From: Scarlett Lambeth <scarlett.lambeth@bartonwillmore.co.uk>
Sent: 10 May 2022 15:36
To: Richard Phillips
Cc: Ed Pigott; Charlotte Thomas
Subject: RE: Silverdale House, Pump Lane, Hayes (Application Ref: 49670/APP/2022/974)

From: Richard Phillips <RPhillips@Hillingdon.Gov.UK>
Sent: 05 May 2022 15:55
To: Scarlett Lambeth <scarlett.lambeth@bartonwillmore.co.uk>
Subject: RE: Silverdale House, Pump Lane, Hayes (Application Ref: 49670/APP/2022/974)

Project
Silverdale House
Hillingdon
Drawing Title
Proposed Elevations

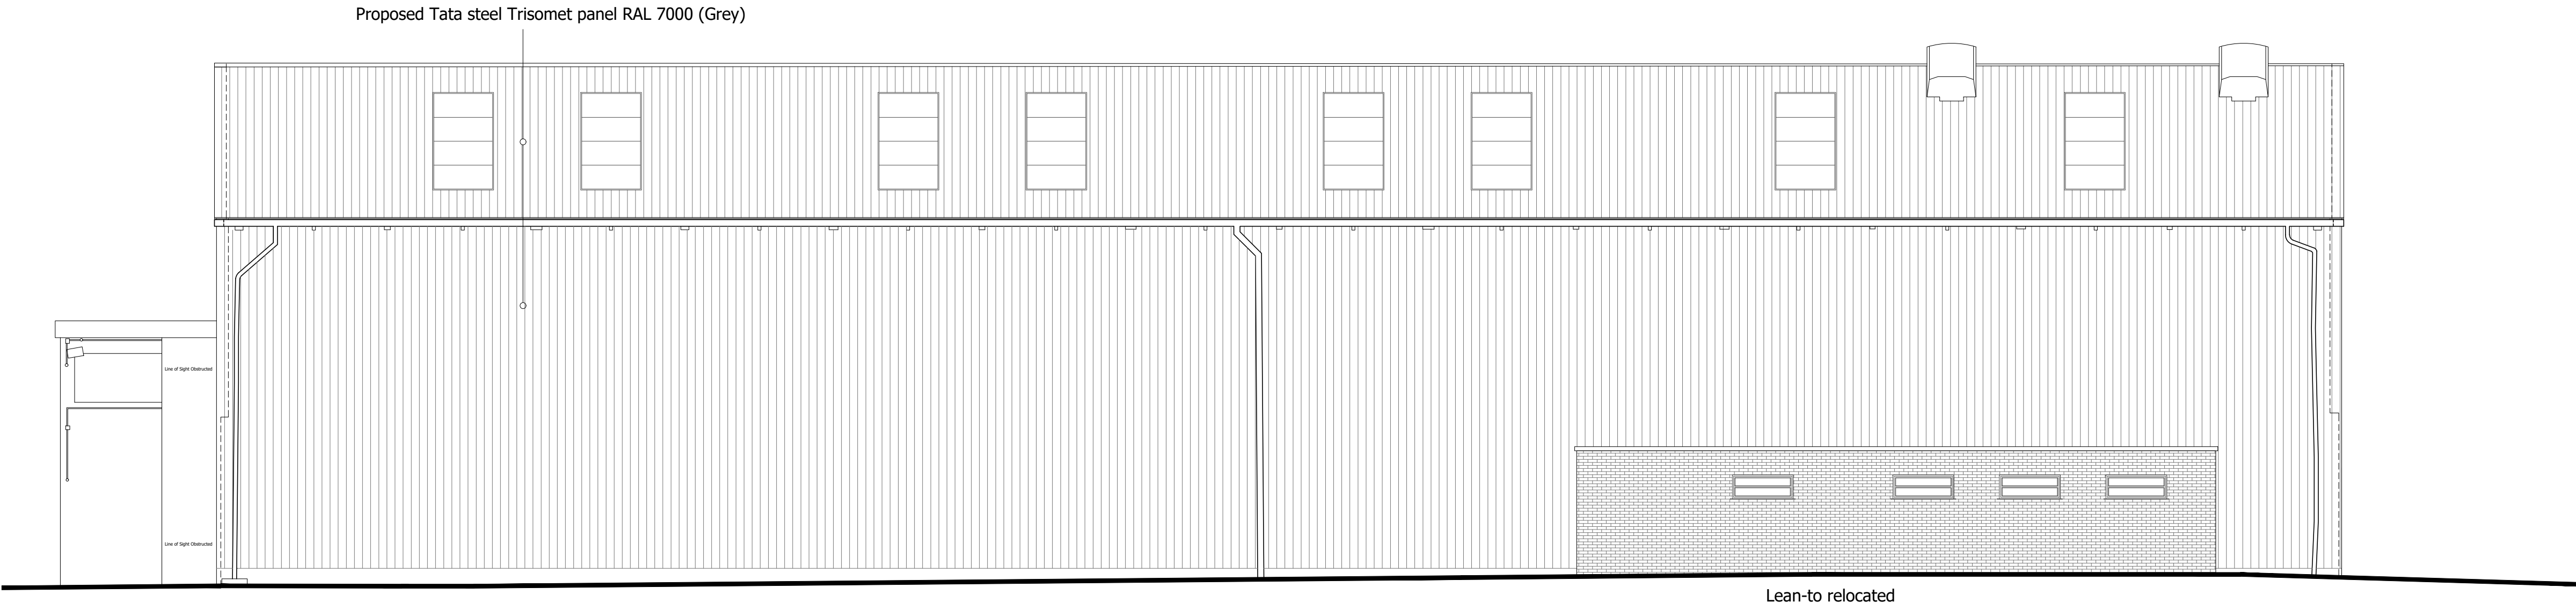
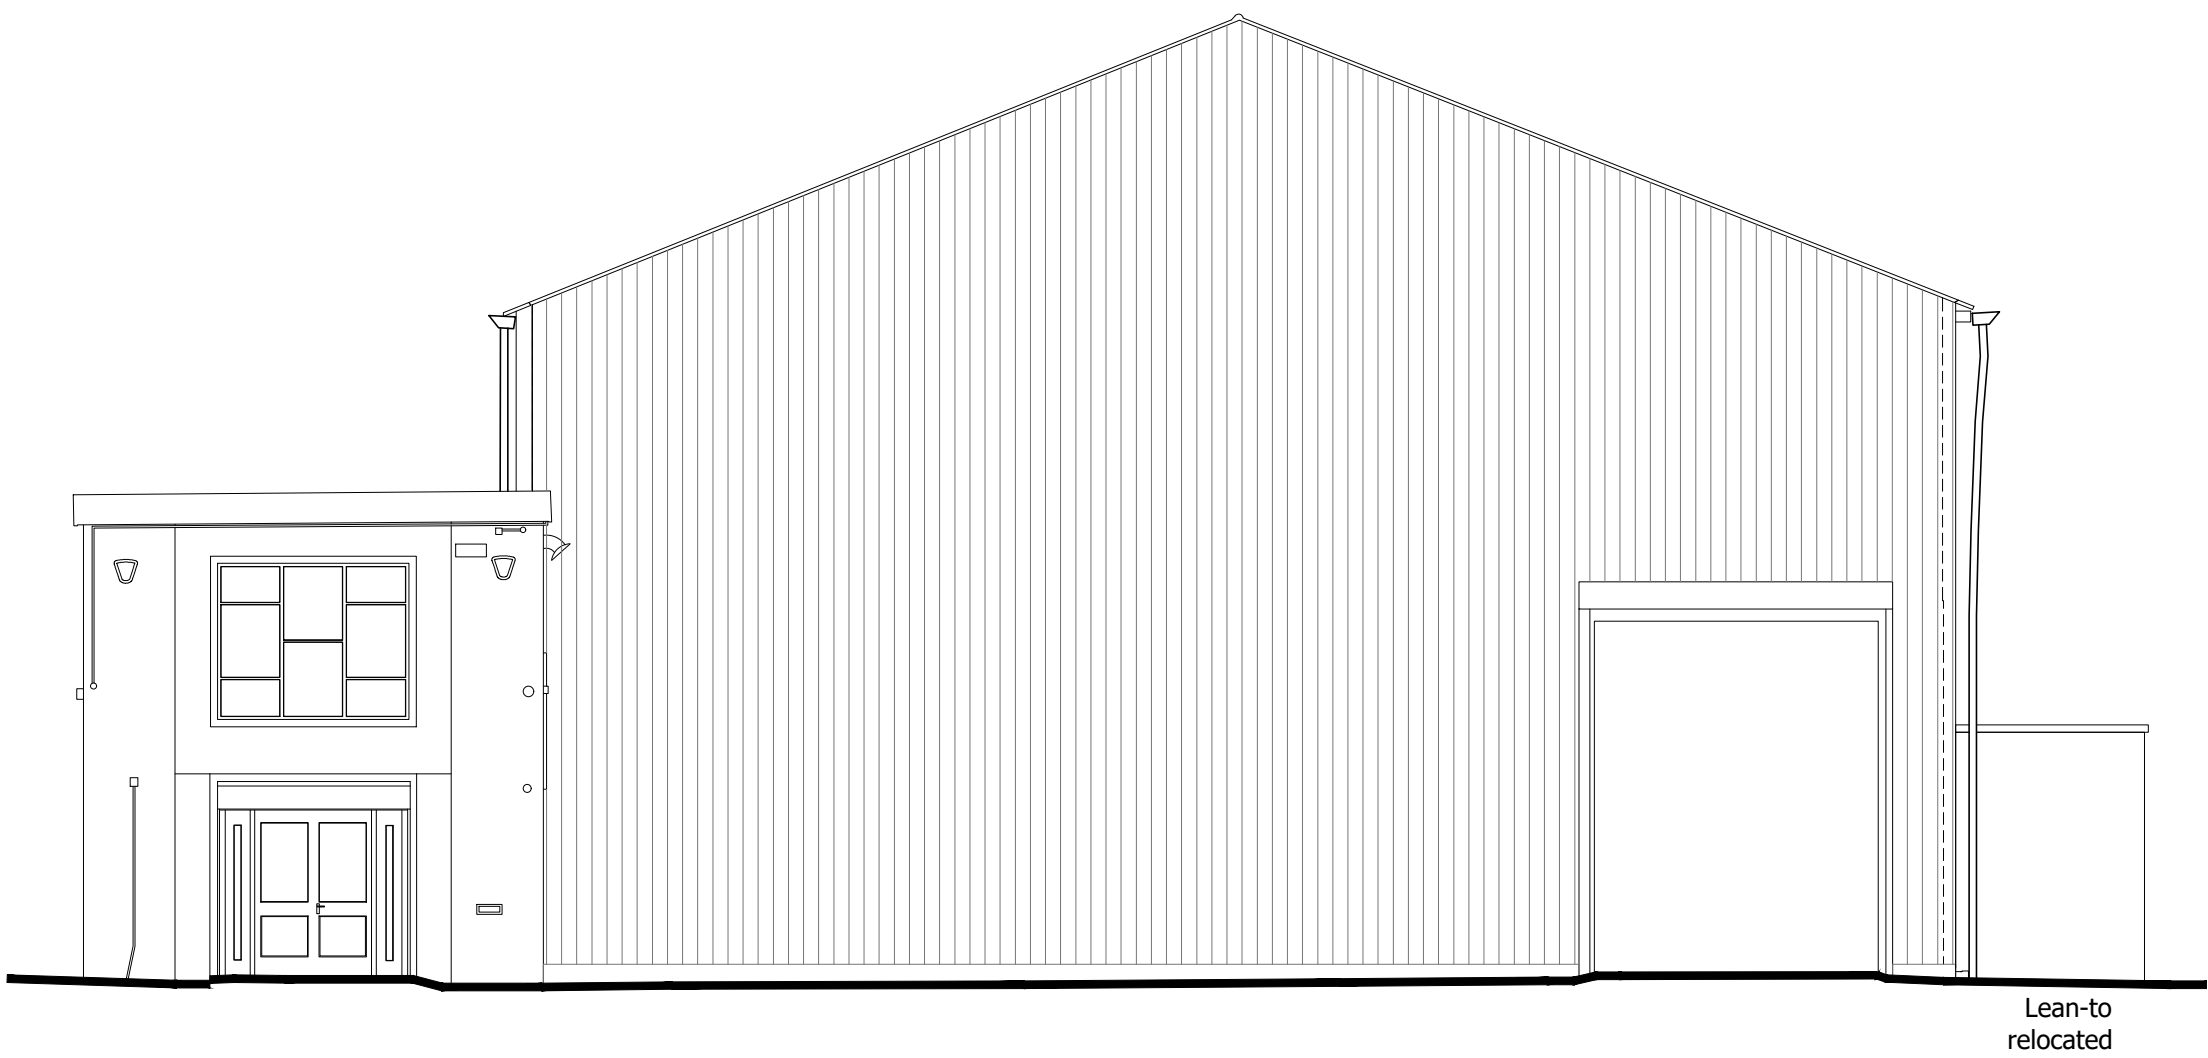
Would you be able to provide further information on the proposed cladding materials – fire safety and whether environmentally friendly being particularly important.

As requested, we've asked the architect to provide some more information in terms of the cladding and they have confirmed they will meet with the required Building Regulations. More specifically, we are proposing a minimum of 120mm insulation, coated steel liners and coated steel outer sheets. Consequently, our understanding is the cladding system (once detailed design has been undertaken) is certified for up to four hours integrity and 15 minutes insulation regarding reaction to fire.
